Donna M. Palmer B. Bus, CPA, MACS.
Quality Assurance Specialist (Retired)

Re: Submission to exhibition of SSD-82709458 at 19-25 Balfour Street, Lindfield

Drawn:
**OVERSHADOWING DIAGRAMS
(PROPOSED)**

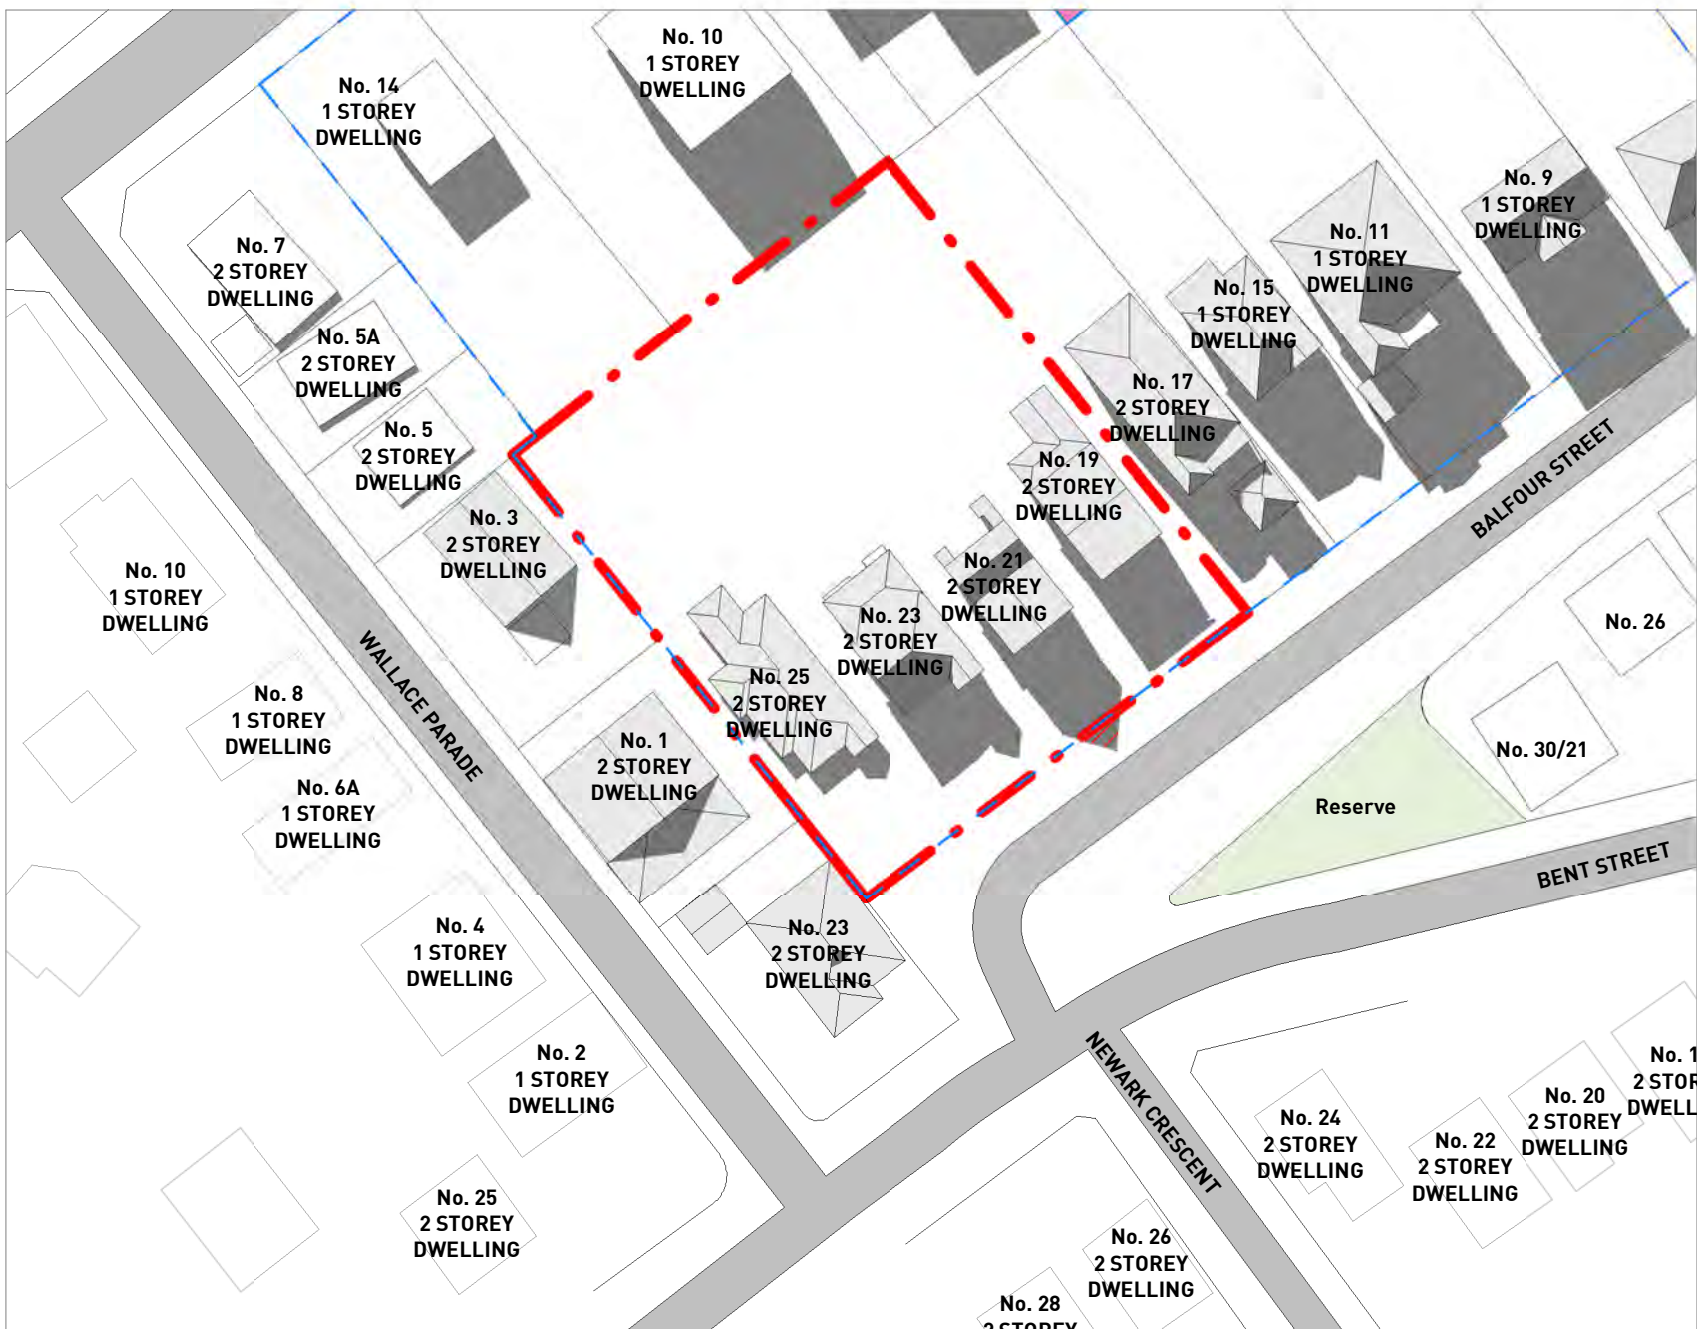
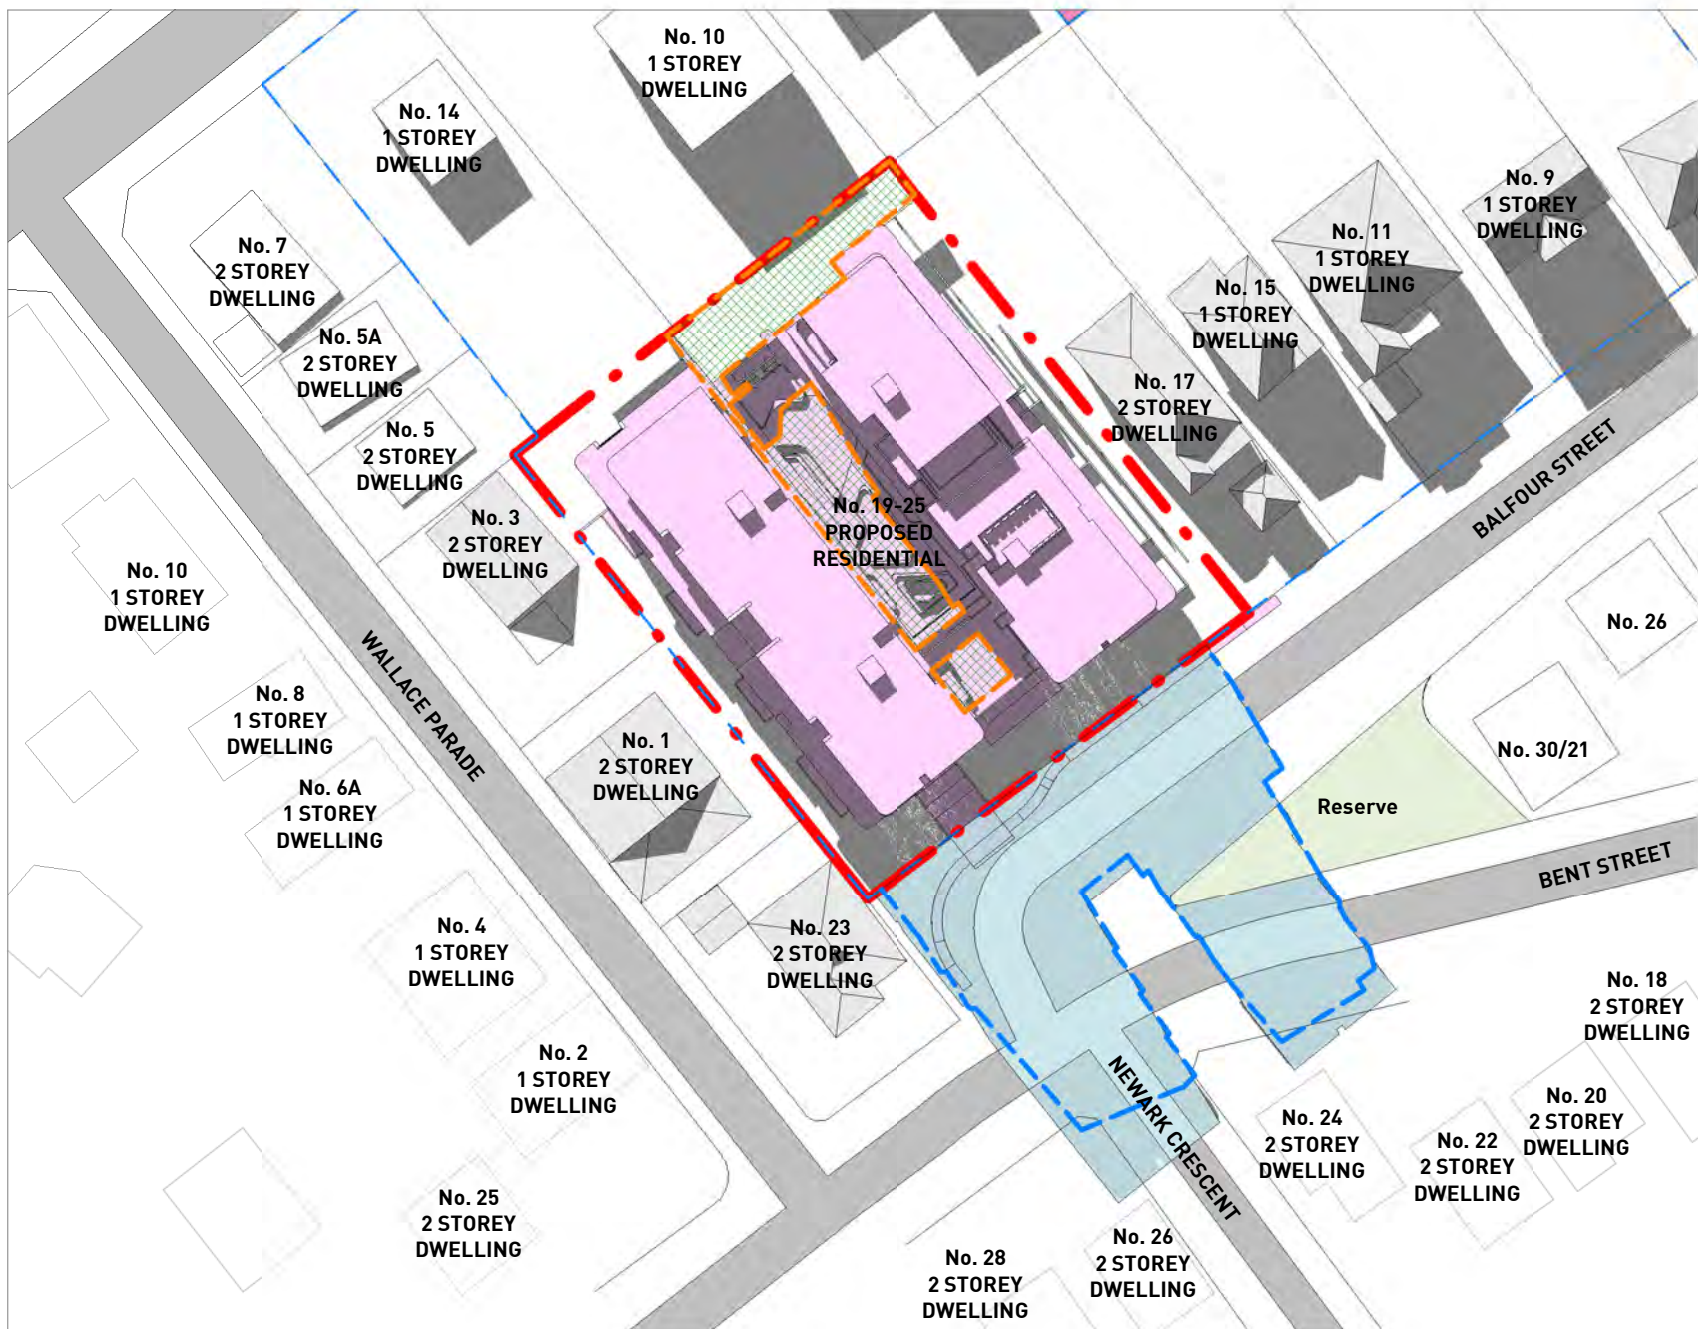
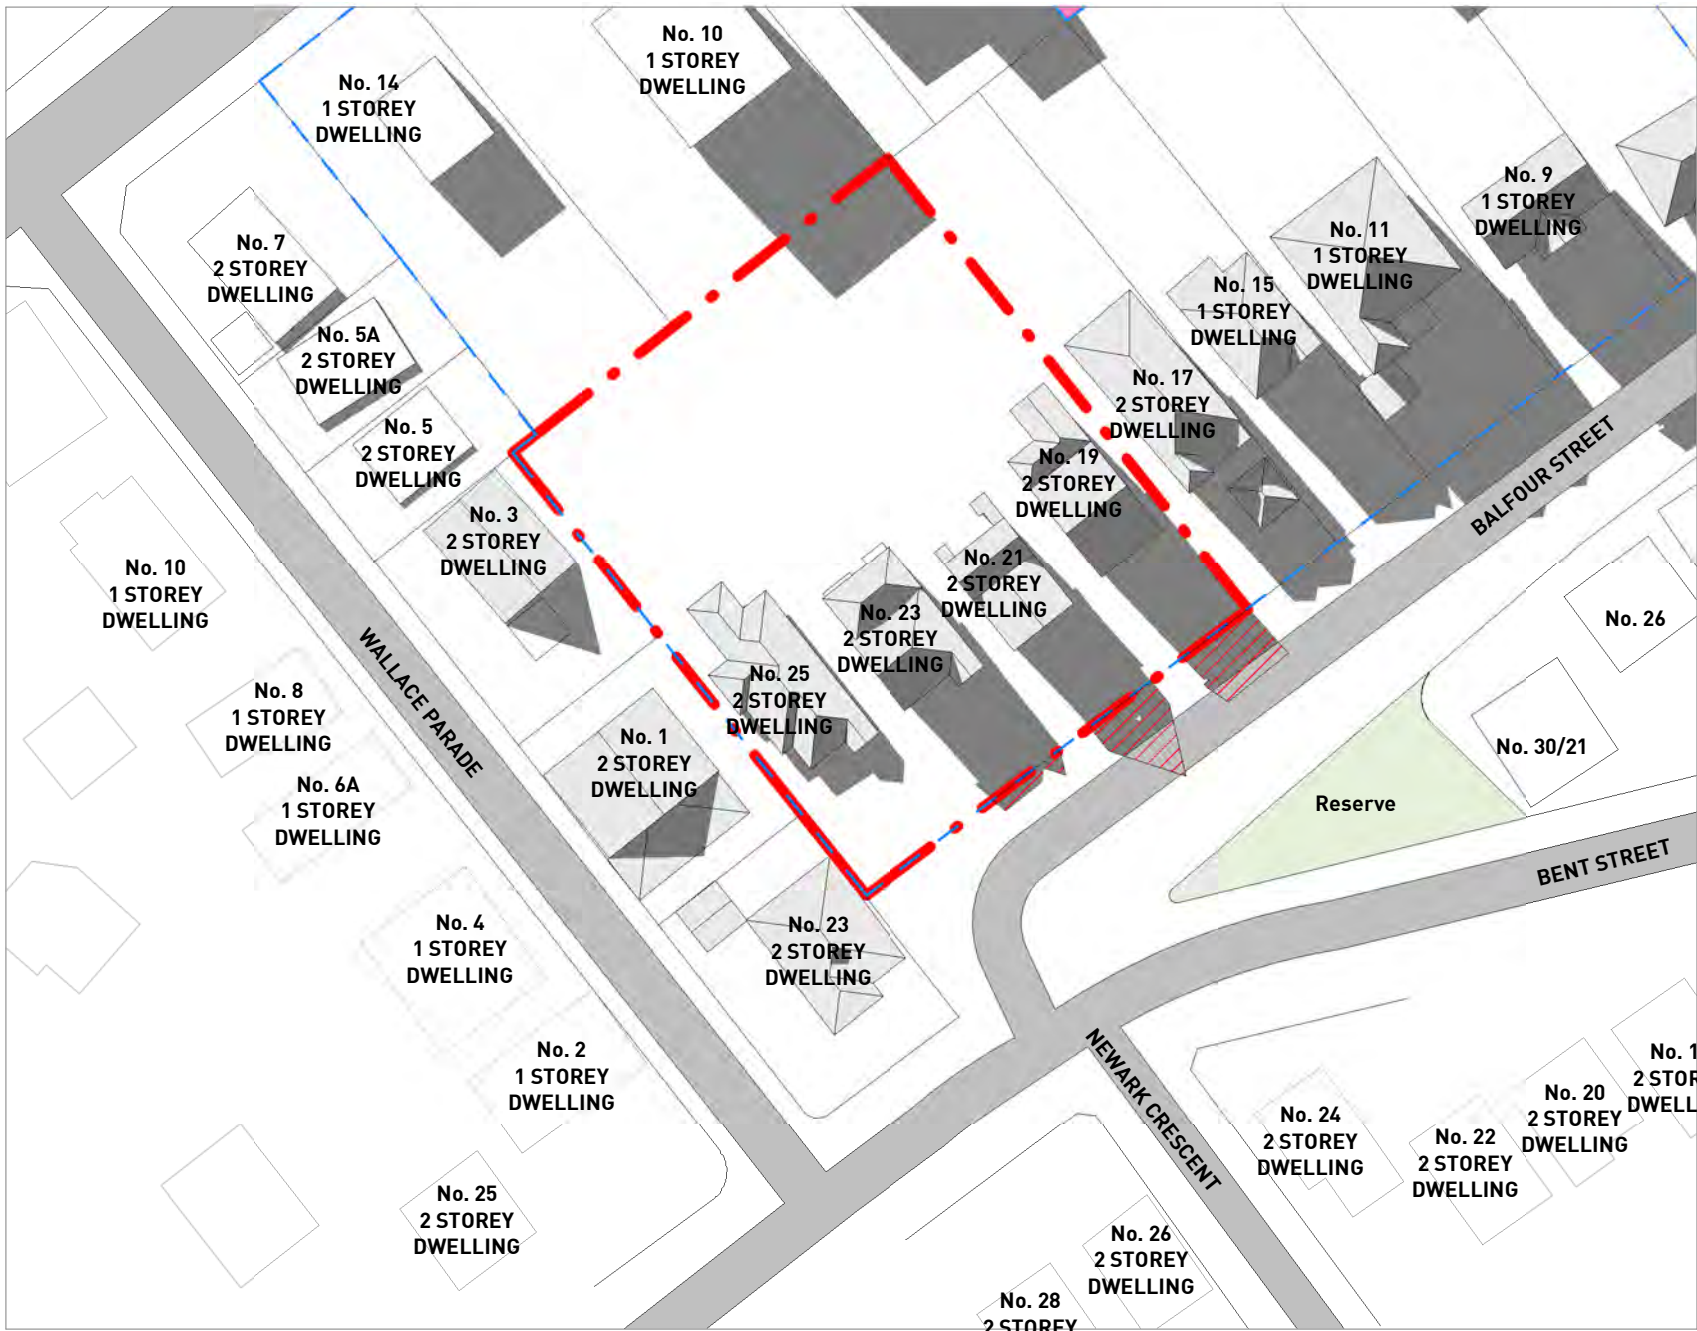
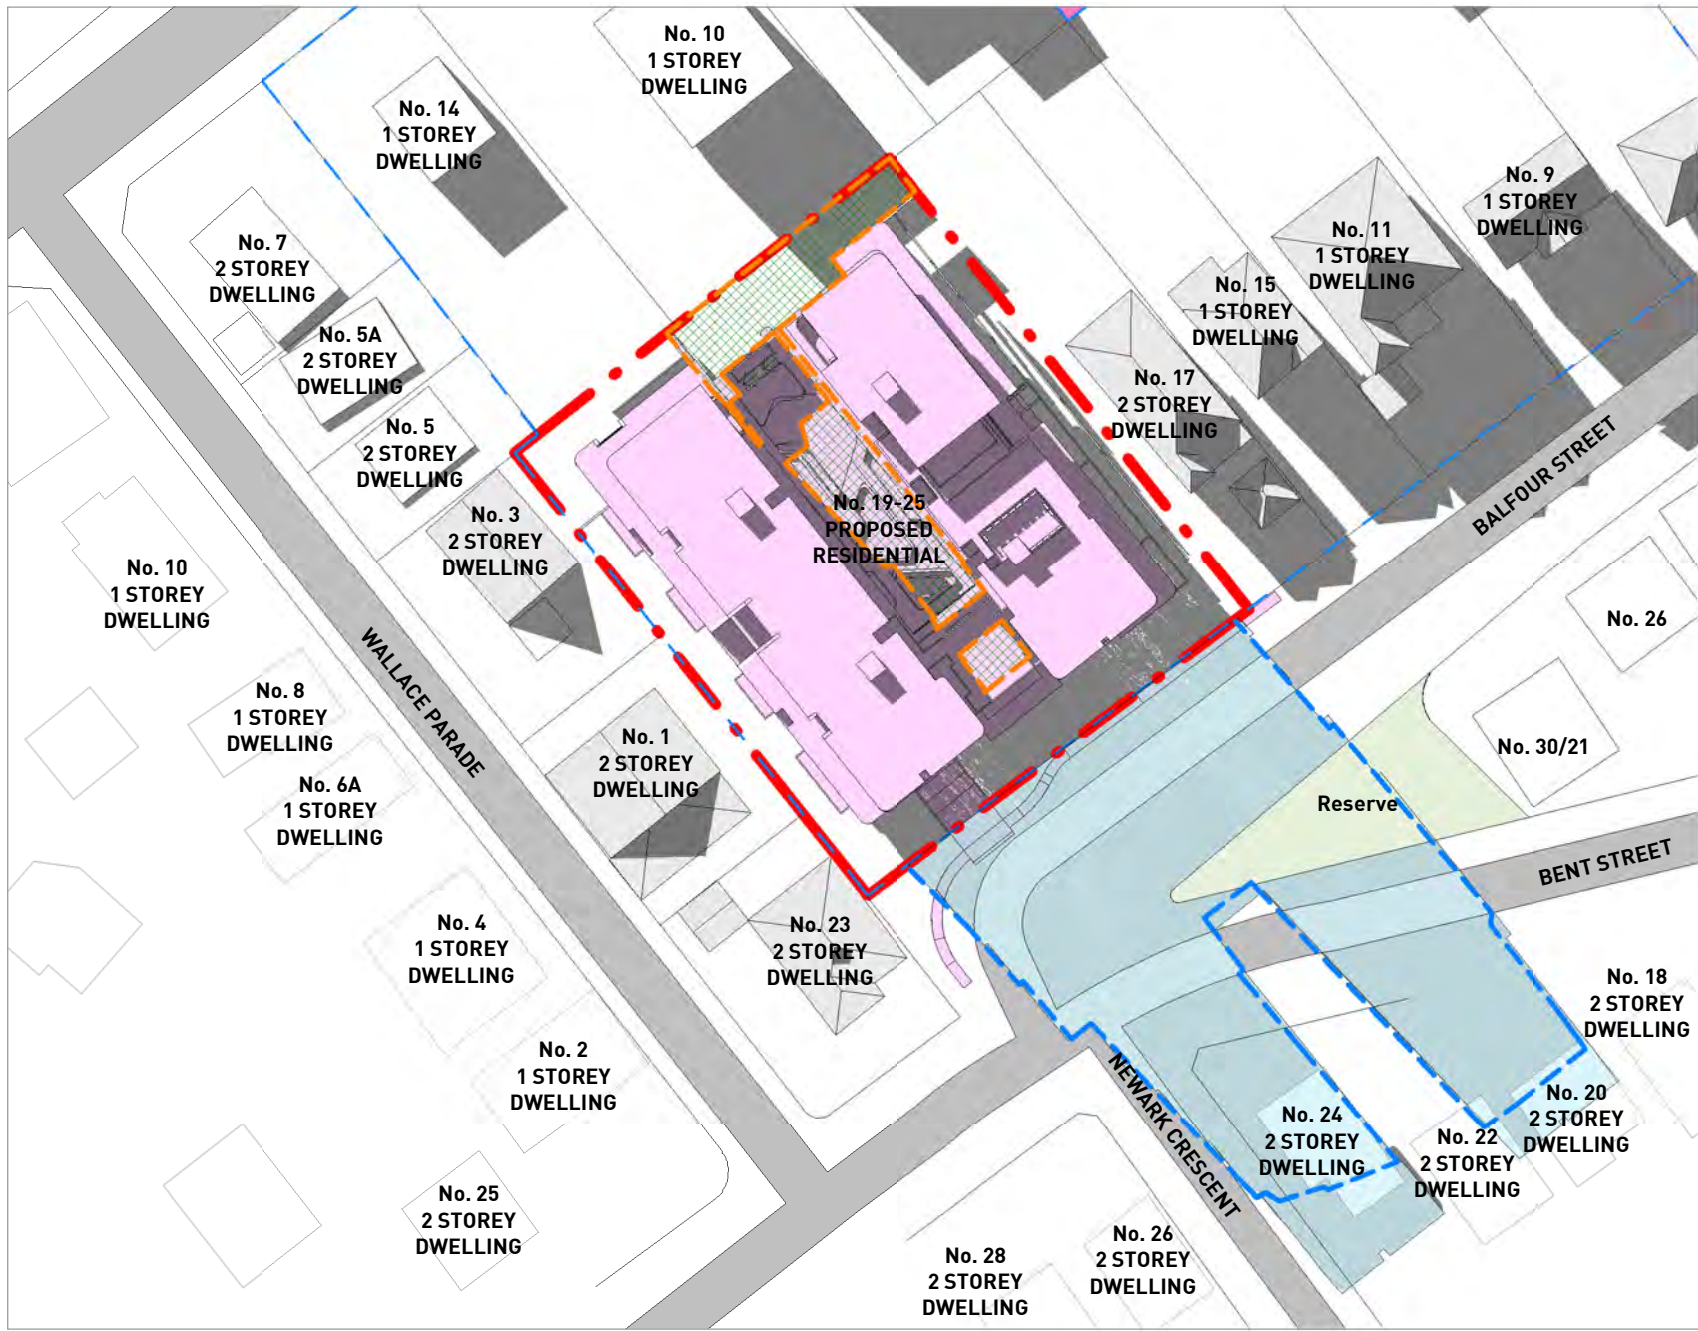
20-24 Bent Street during winter will be completely in shade from 2:30pm onwards during winter solstice, meaning any solar access or solar panels installed there will be ineffective. Thus, the height of this development must be reduced.
